Comment Log for Rolling Meadows Channel & Floodplain Modification - 60% Design Plans

REVIEWERS															
Reviewers: El Paso County Engineering & El Paso County Stormwater				3/1/2023		MATRIX RESPONSE Disposition Key: A = Will Incorporate, B = Will Evaluate, C = Will Incorporate in Later Submittal, D = Other			Date: 3/06/2023		MATRIX RESPONSE Disposition Key: A = Will Incorporate, B = Will Evaluate, C = Will Incorporate in Later Submittal, D = Other			Date: 4/27/2023

| DESIGNED BY: TKM | SCALE: HORIZ 1" = 500' | DATE ISSUED: JANUARY 2023 | DRAWING No. DR01 |

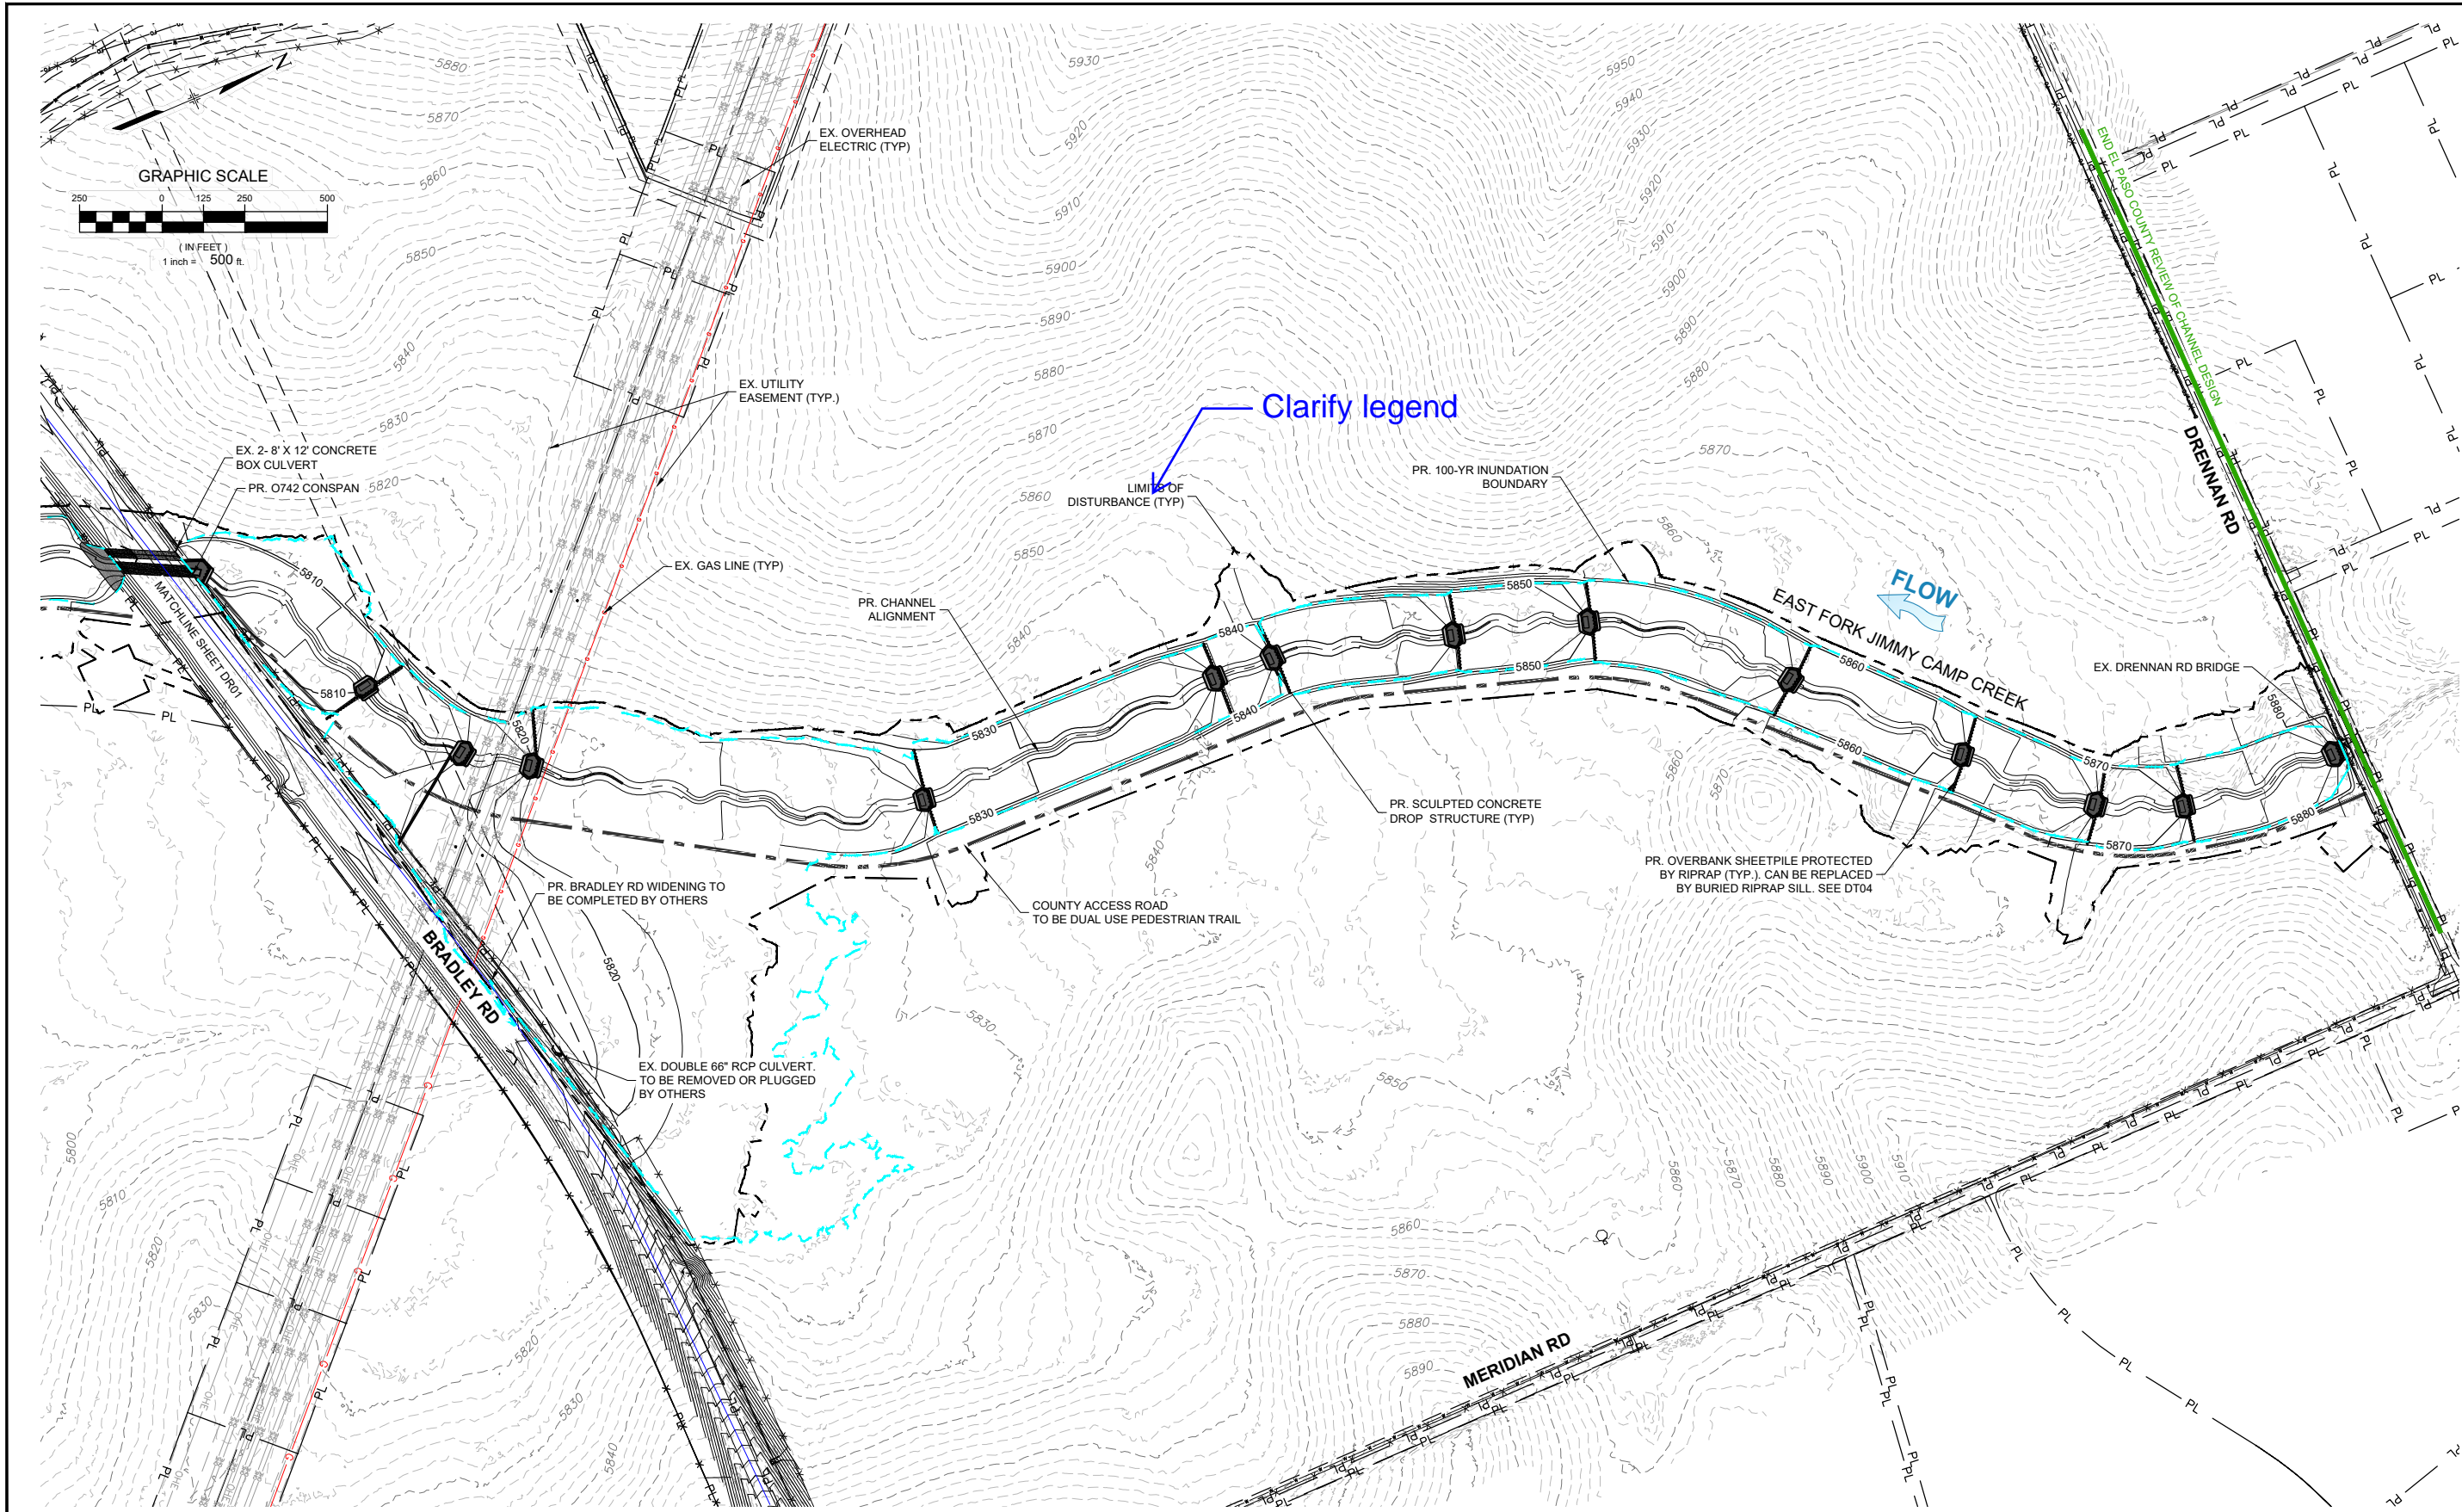
DR01						Can this be filled in if the BLR swale isn't constructed.	JR	D	The area is the be "plugged" regardless as it is anticipated that site grading will be completed on the eastern bank of the proposed channel for development. This drainage will be eliminated.	TKM				
6	DR02	Clarify legend	EPC Engineering	A	Line width/scale adjusted in GN01 legend. Does this address your comment?	EAL	Some linetypes are still different than legend.	JR	A	Modified	TKM				
7	HZ01/02	Alignment table or centerline labels will need to be added on this sheet or on the plan & profile sheets	EPC Engineering	A	Line & curve tables added on HZ03	EAL	Add line and curve labels to HZ01 and HZ02	CD/JR	A	Modified	TKM				
8	EC01	These sheets should be included in the GEC Plan or all GEC Plan Sheets should be added to the Design Plan	EPC Stormwater	A	Removed	EAL	Add these sheets to GEC Plan?	CP	A	We felt the information was covered in the GEC plans but we added the information to the overview sheets	TKM
